13 July 2011

Section 75W Modification to MP 10_0145 – Design Changes
Sydney Showground Main Arena Redevelopment, Sydney Olympic Park

The submitted plans by Populous illustrate the proposed changes and **Appendix B** provides a graphic, simplified summary of more notable changes at each level as follows (the complete architectural package is attached as **Appendix C**):

SHEET TITLE:
Level 1 Floor Plan - Overall Stage 1a

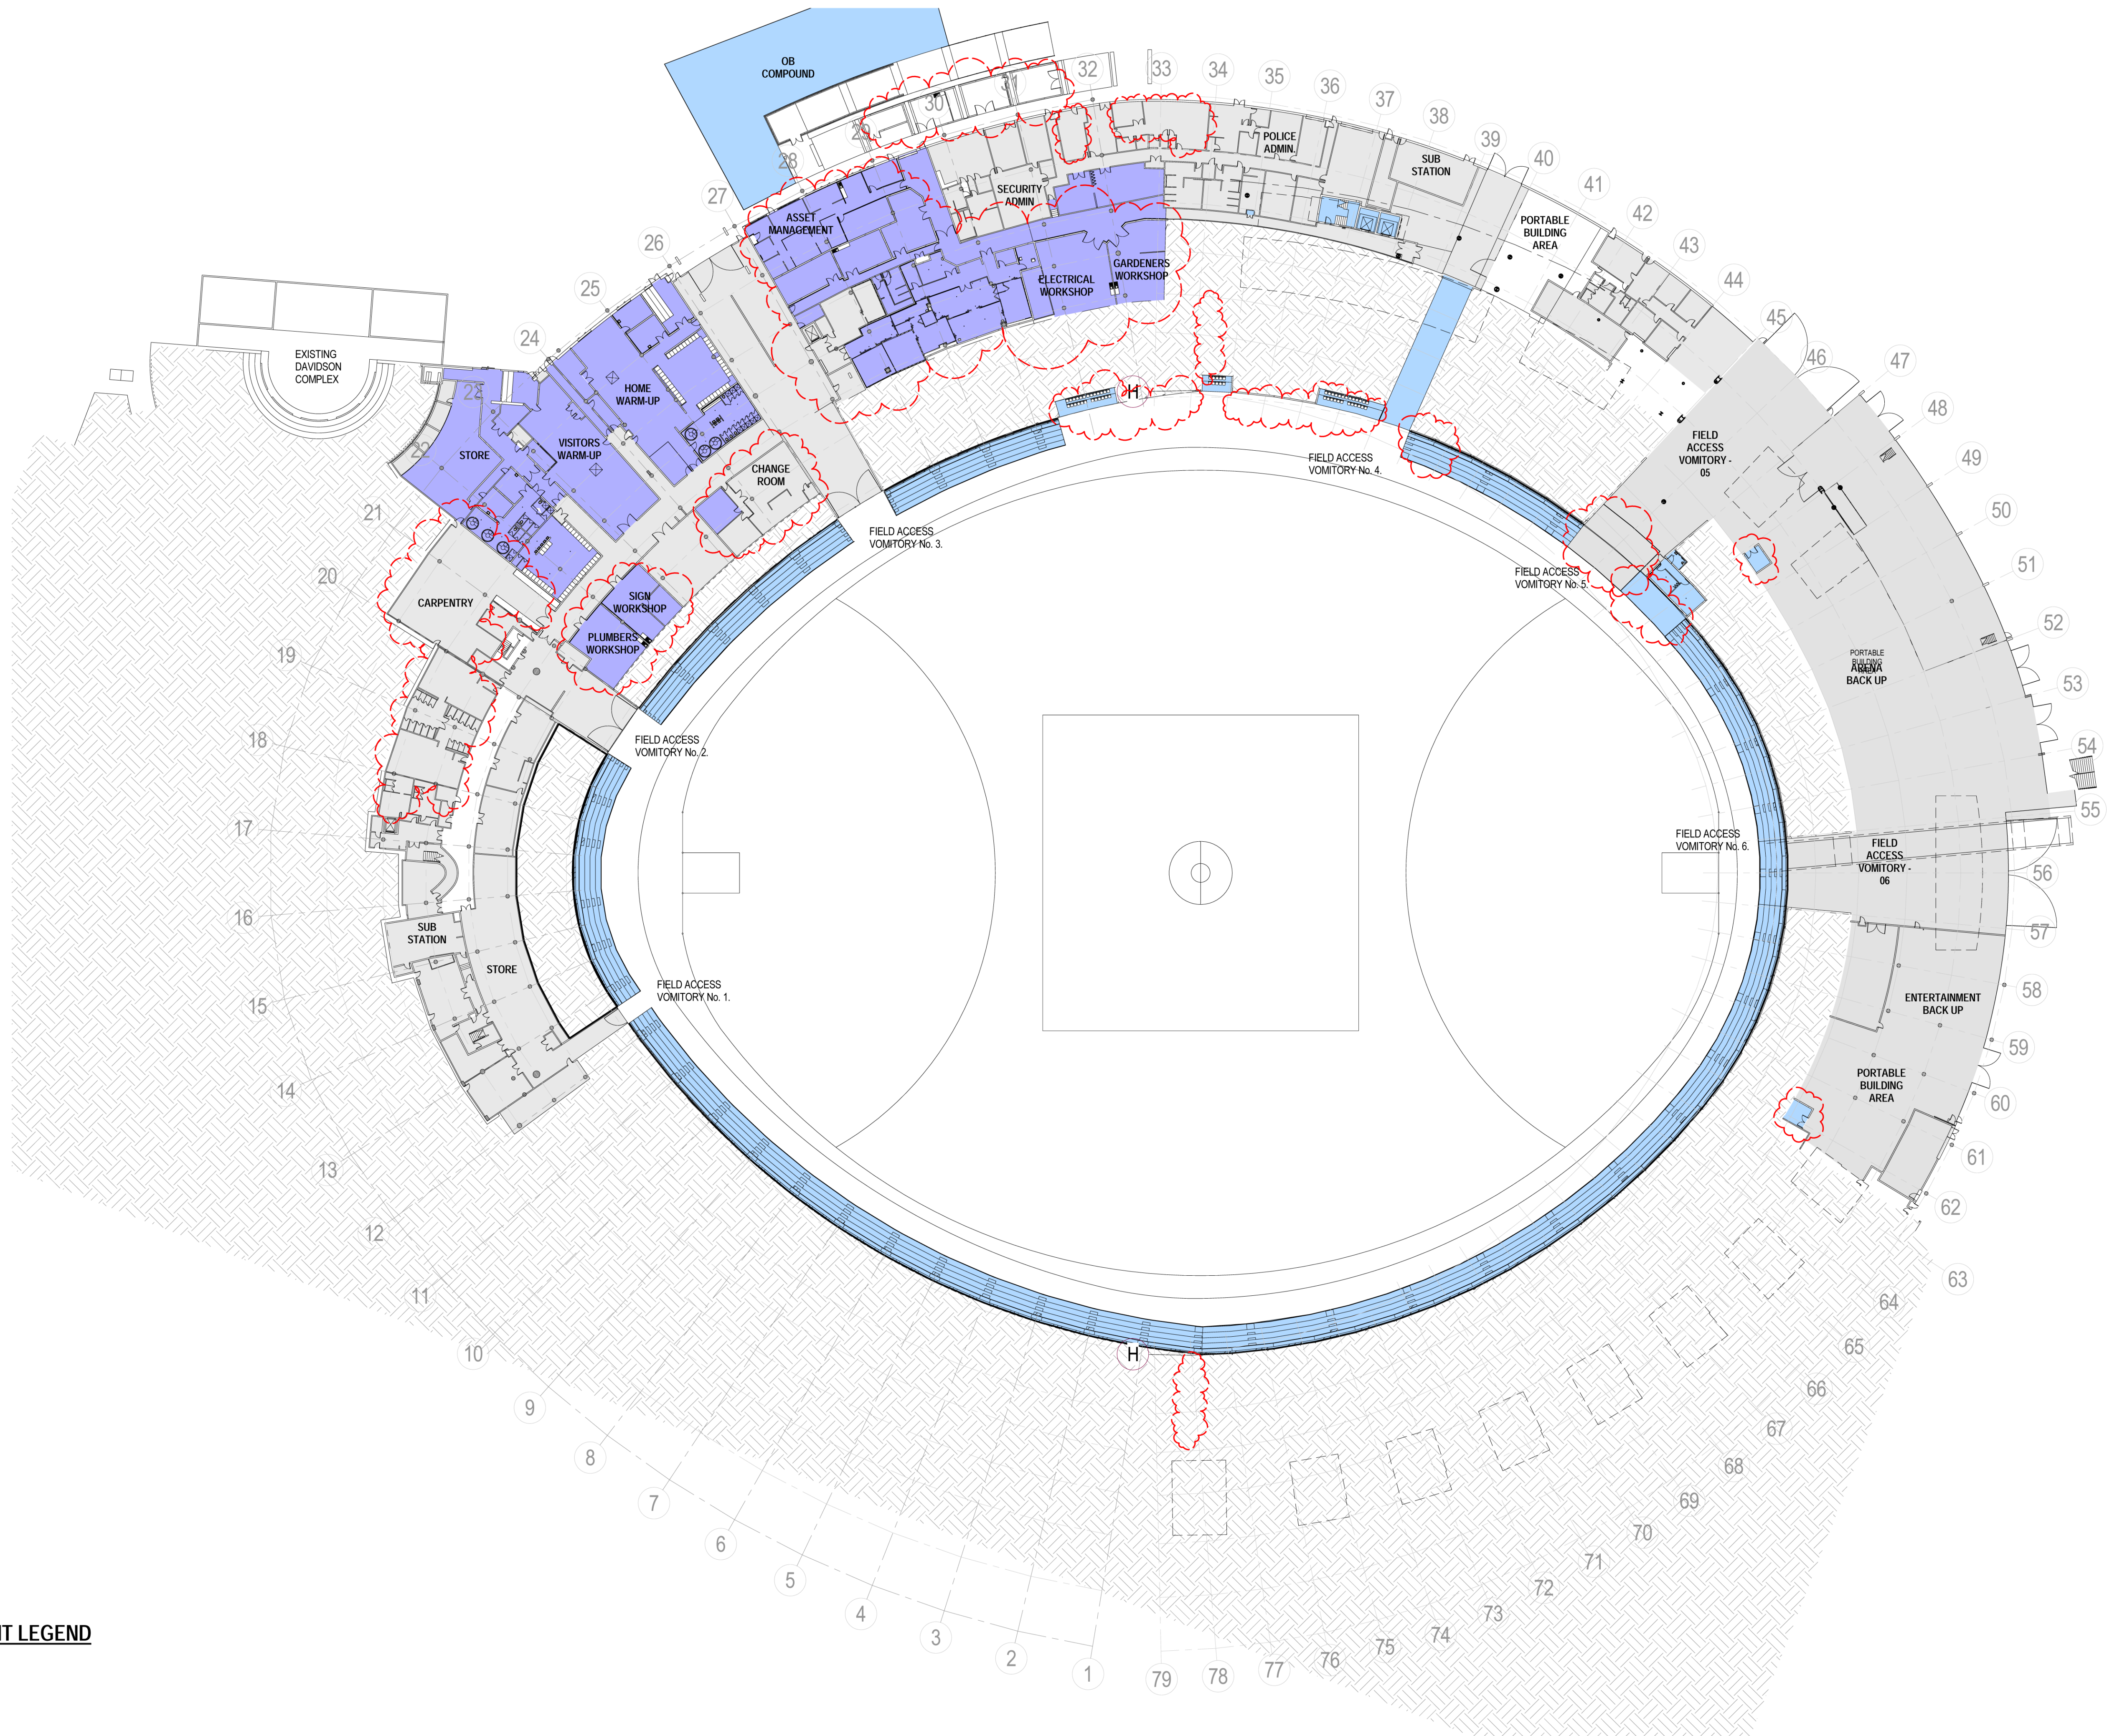
LEVEL	CHANGES
Level 1	<p>Relocation of utility and back of house areas;</p> <p>Deletion of a previously proposed club lounge;</p> <p>Expansion of kitchen;</p> <p>Addition of OB Compound.</p>
Level 2	<p>Addition of entry portal for Gate A and Gate B;</p> <p>Rationalisation of bar areas;</p> <p>Consolidation of NW amenity and relocation of two previously proposed NW and NE amenity blocks next to F&B under the videoboard;</p> <p>Deletion of previously proposed hill seating area</p>
Level 3 and 4	<p>Deletion of the previously proposed NW upper tier grandstand</p> <p>Deletion of previously proposed two bays from the SE upper tier grandstand in</p> <p>Addition of fire stairs</p>
Roof Plan	Construction of roof over both new stands in Stage 1a
Elevations	<p>Amendment to reflect revised grandstands</p> <p>Redesign and relocation of previously approved light towers</p> <p>Removal of green wall from NW section of corporate stand and redesign of corresponding façade</p> <p>Redesign of Charlie Room link bridge and adjacent level 3 façade as unenclosed space without green wall element</p> <p>Amendment to reflect relocated amenity blocks and deleted hill seating</p> <p>Redesign of videoboard from a rectangular form to an oval form</p>
